# Appeal Decision

## **Appeal Ref: APP/T2350/3177455**

### **Fields Farm Barn, Back Lane, Chipping PR3 2QA**

- The appeal is made under section 78 of the Town and Country Planning Act 1990 against a refusal to grant planning permission.
  - The appeal is made by Mr Derek Balchin against the decision of Ribble Valley Borough Council.
  - The application Ref 3/2017/0308, dated 29 March 2017, was refused by notice dated 25 May 2017.
  - The development proposed is formation of new window openings in existing dwelling
-

Drawing Title
 EXISTING PLANS & ELEVATIONS

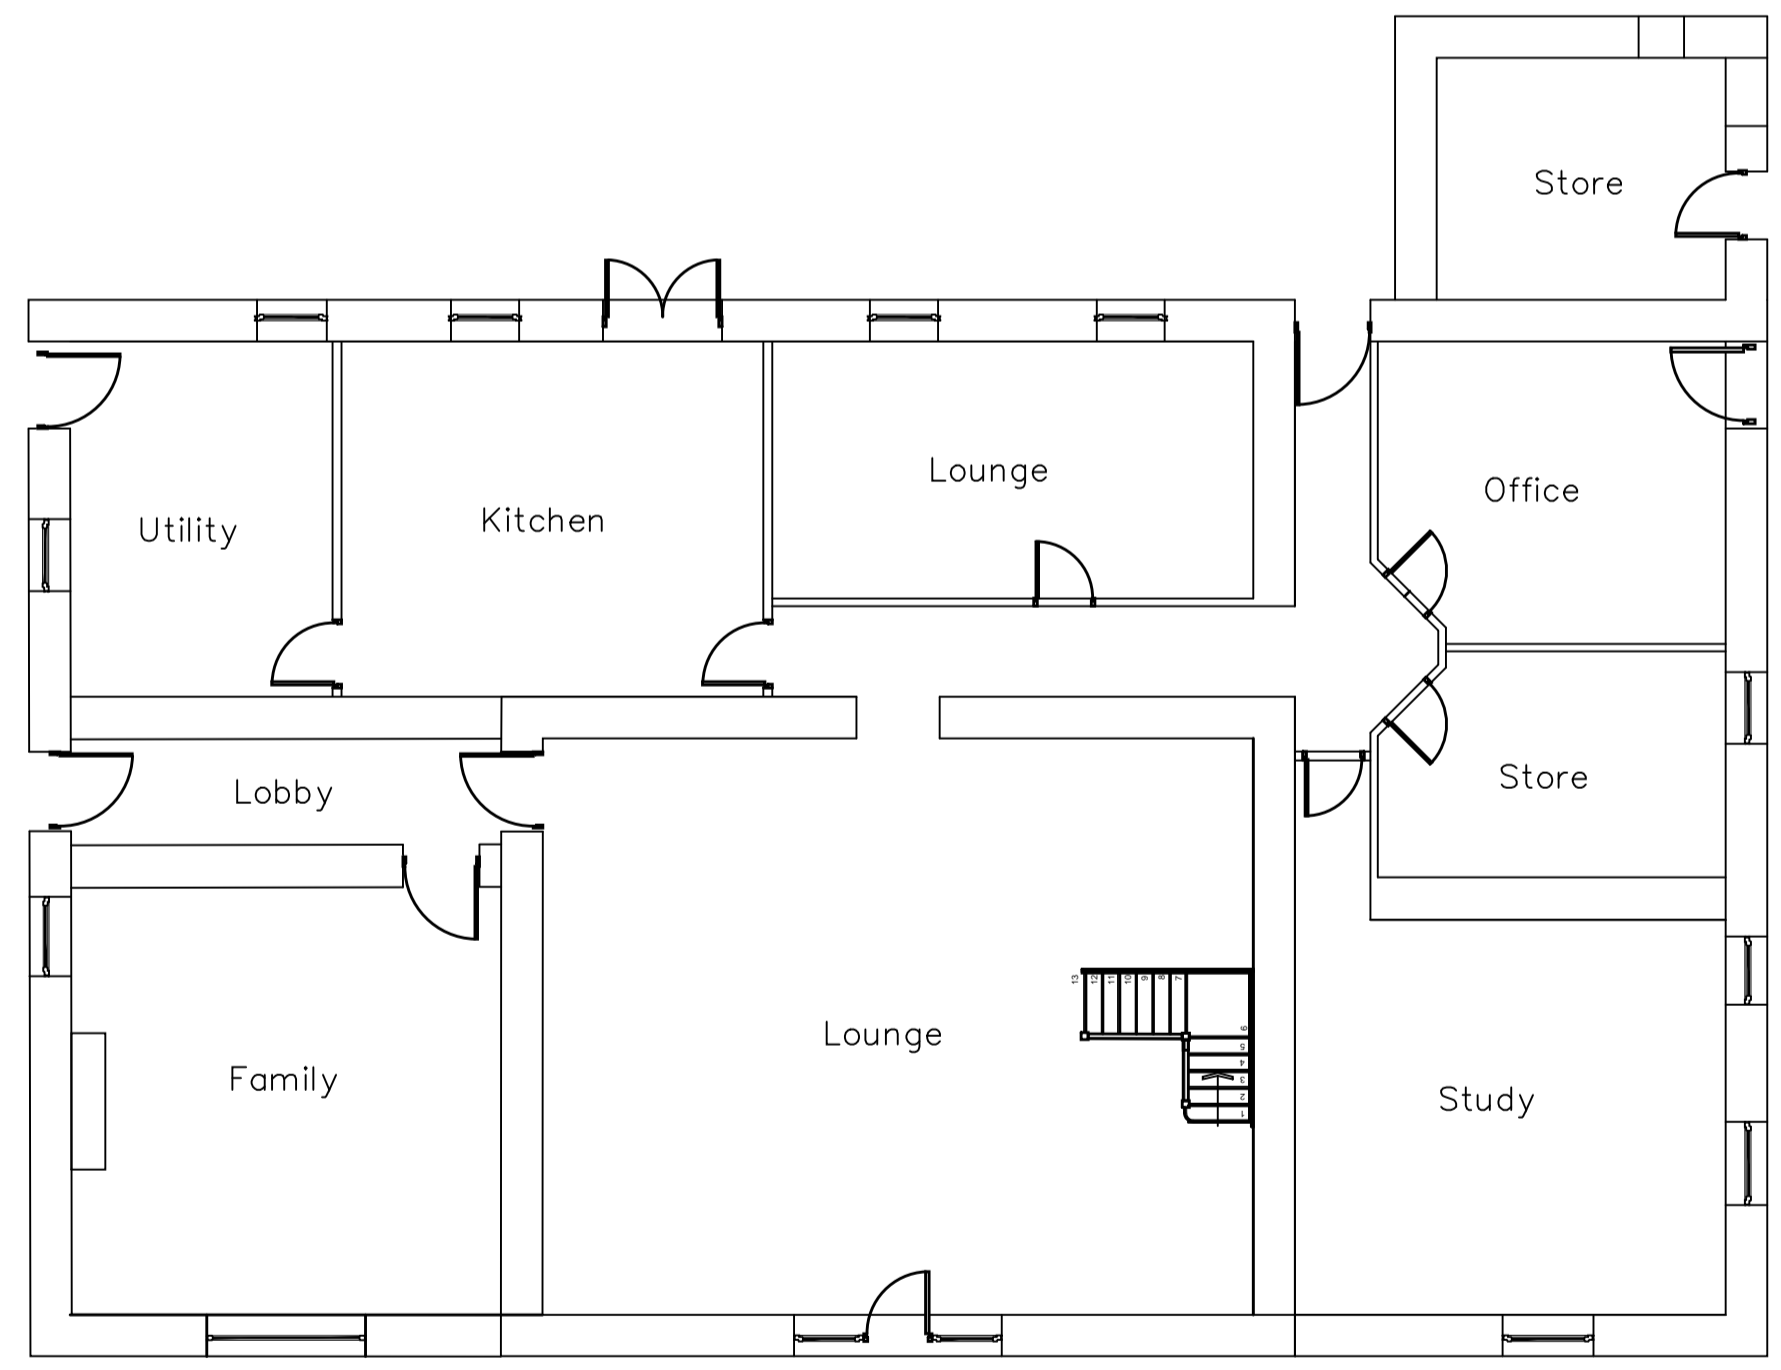
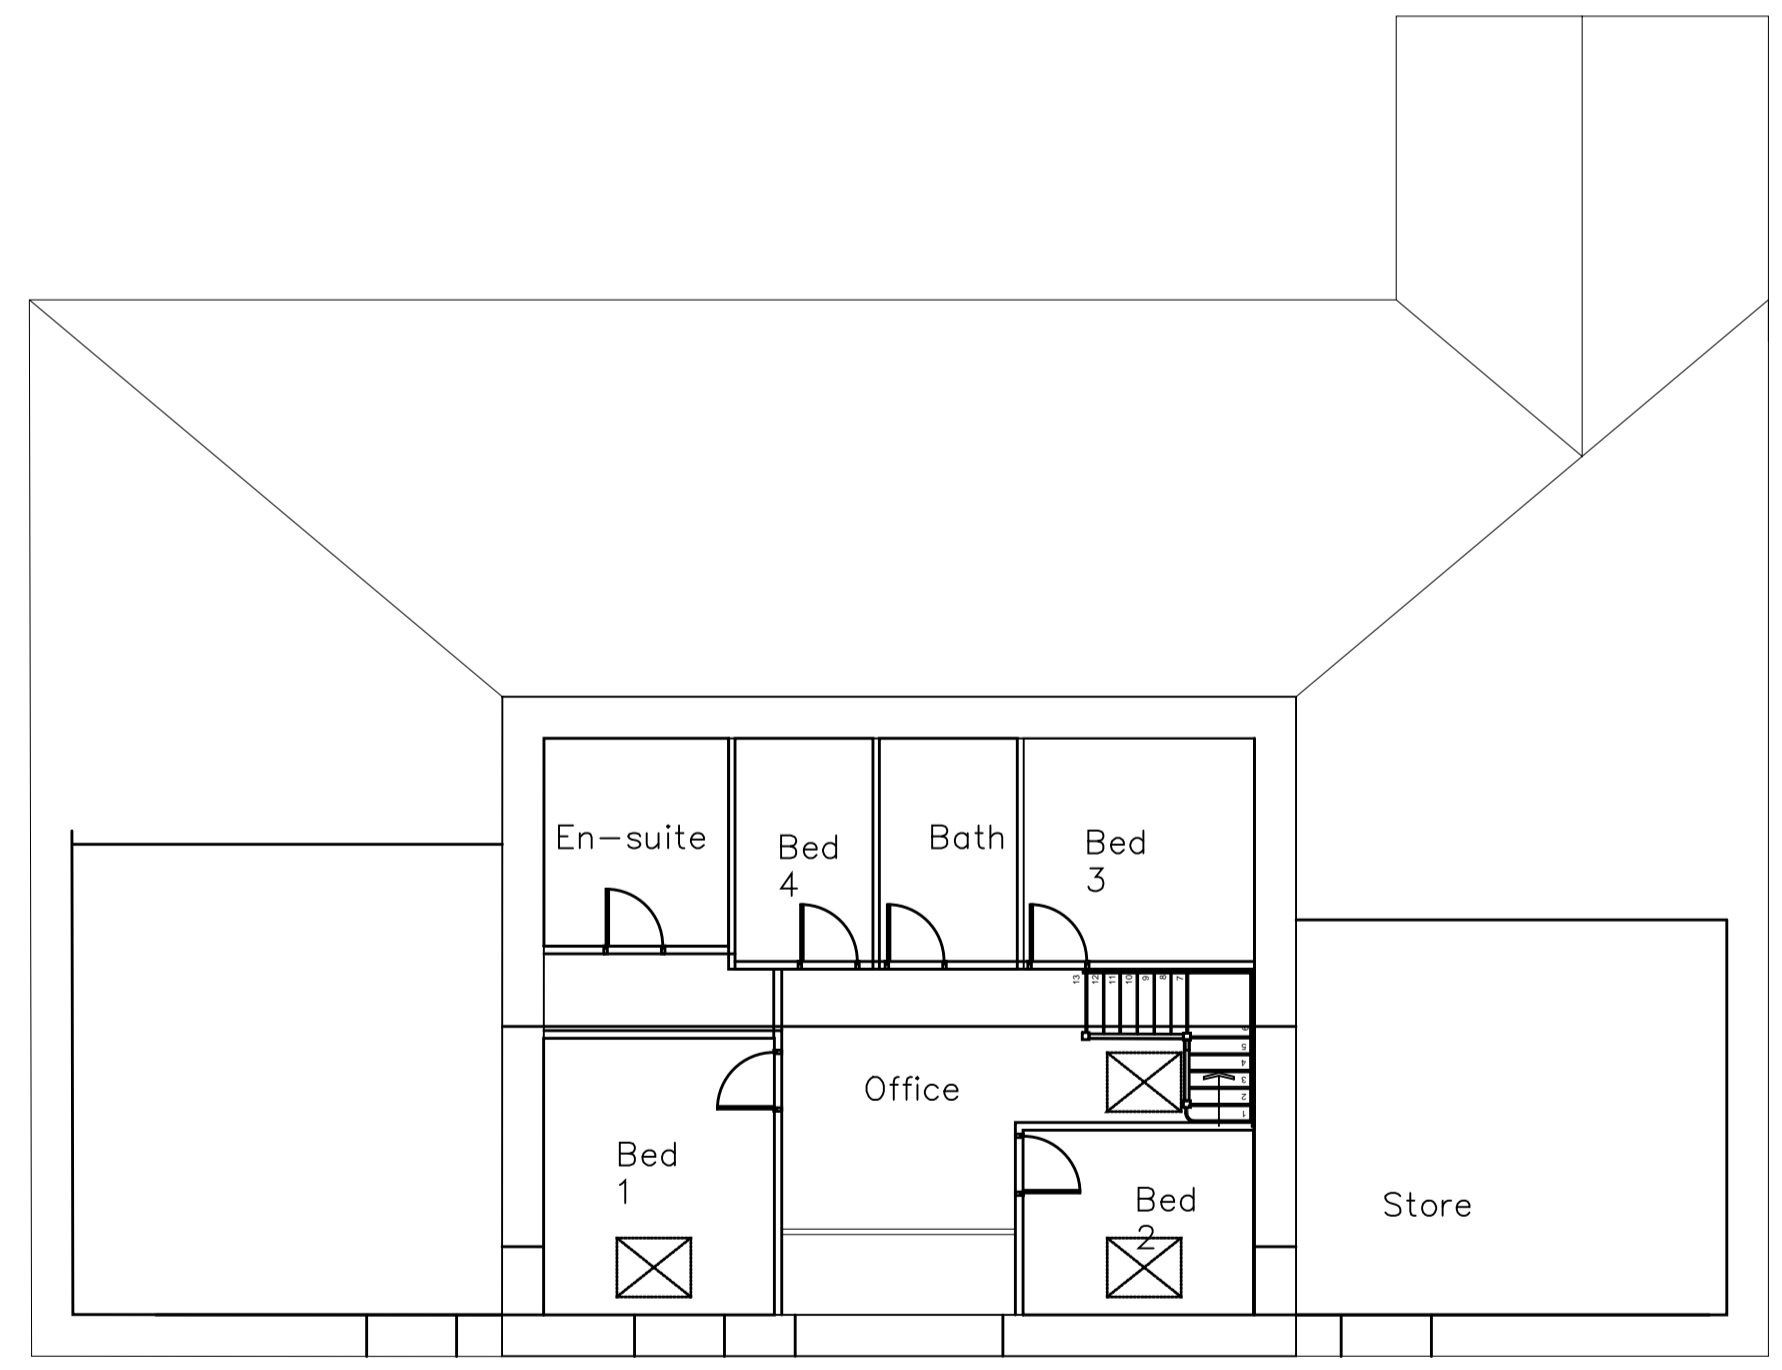
2. Part of the proposal involves the insertion of a new rooflight into the roof on the elevation of the appeal property furthest away from the farmhouse. This is marked as the north west elevation on the plans, but I believe this is the south west elevation. The existing plan<sup>1</sup> does not show any rooflights on the roof of that elevation. On my site visit however, I noticed that there was a rooflight in place on the roof above the door, albeit in a slightly higher position than shown on the submitted proposed plan<sup>2</sup>.
3. I also noticed that there were two additional rooflights on the roof of that elevation and a porch, which are not shown on the submitted plans.

PROPOSED PLANS & ELEVATIONS

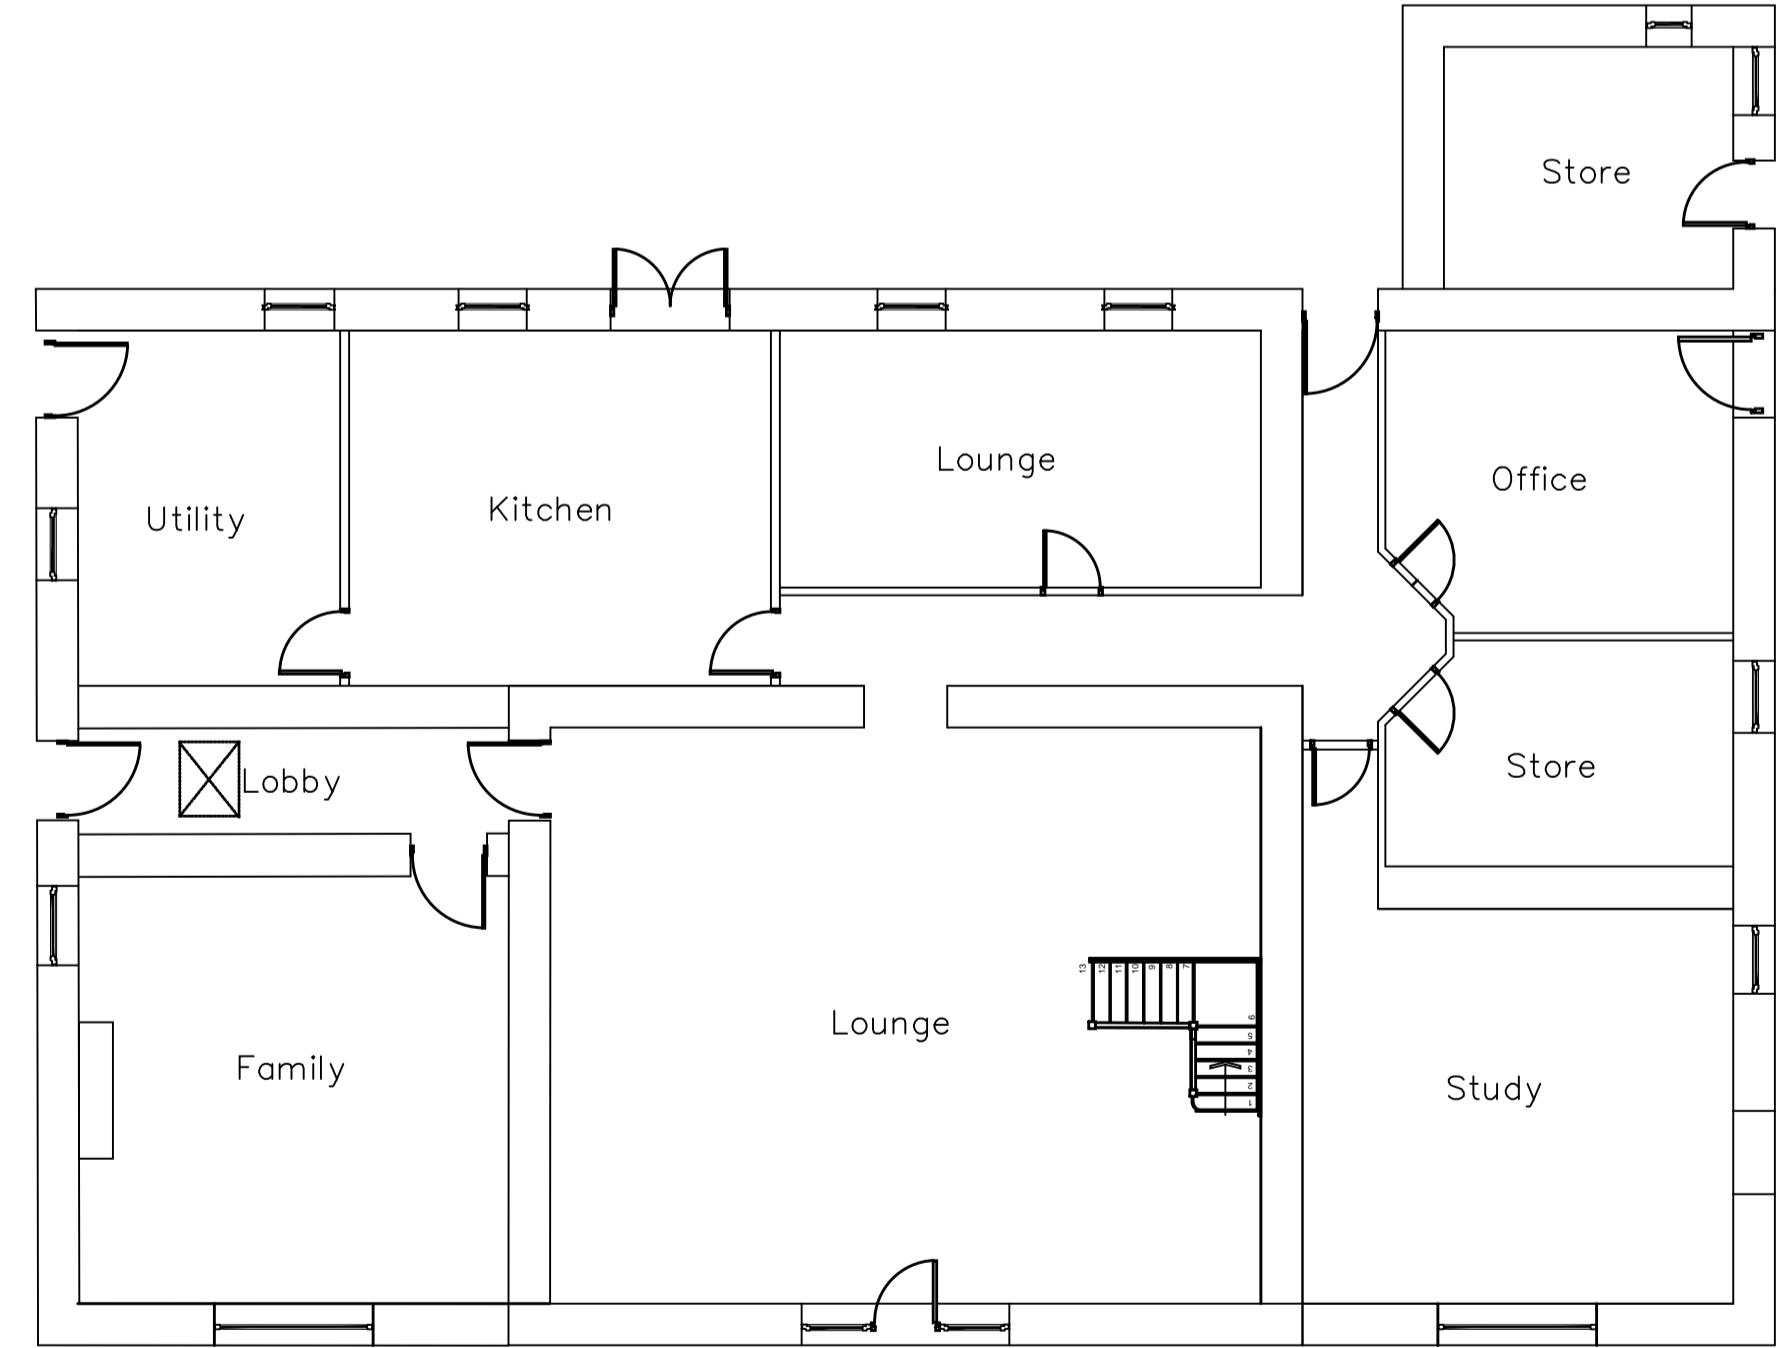
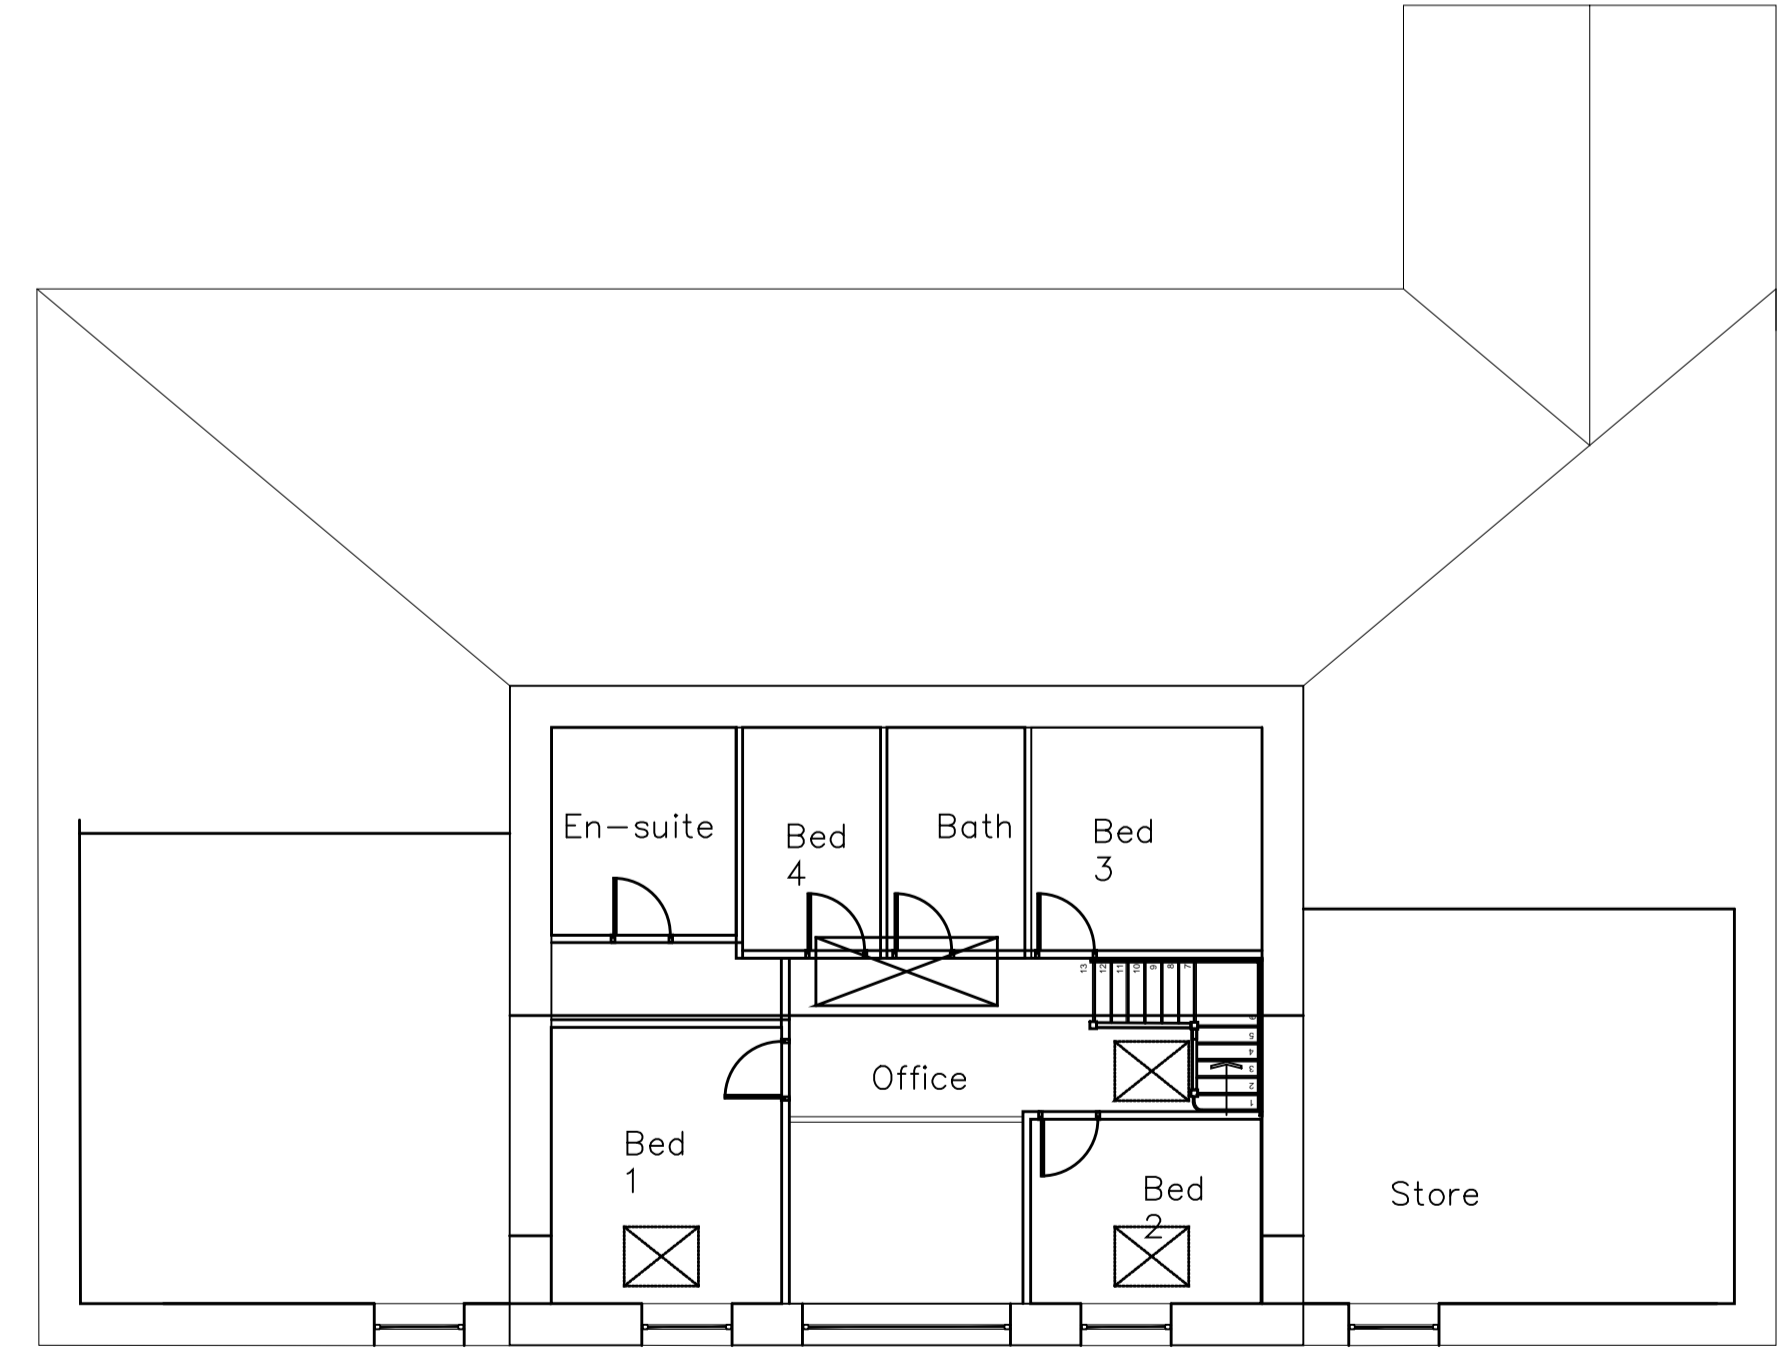
9. The proposed rooflight is a minor addition to the roof of the side elevation of the appeal property and I consider that it would not be harmful to the character and appearance of the property.

10. The small higher window openings of the side elements of the appeal property are consistent with the character and appearance of the property as a former barn, and therefore I consider that the window proposed in the existing window opening on the south east elevation would not be harmful to its character and appearance.

11. The new proposed window on the central part of the barn would introduce symmetry to that elevation, increase the number of openings, and affect the glazing to solid ratio. However, given its size and that it reflects the design and relationship of the existing openings on that elevation, I consider that the window would not have a harmful effect on the character and appearance of the appeal property.

12. The proposed larger full length glazed window, which would replace the existing square window, would increase the ratio of opening/glazing to solid

wall. Although this part of the proposal would mirror the other side of this elevation, I do not consider that this would create a domestic form or be detrimental to the character and appearance of the building overall.
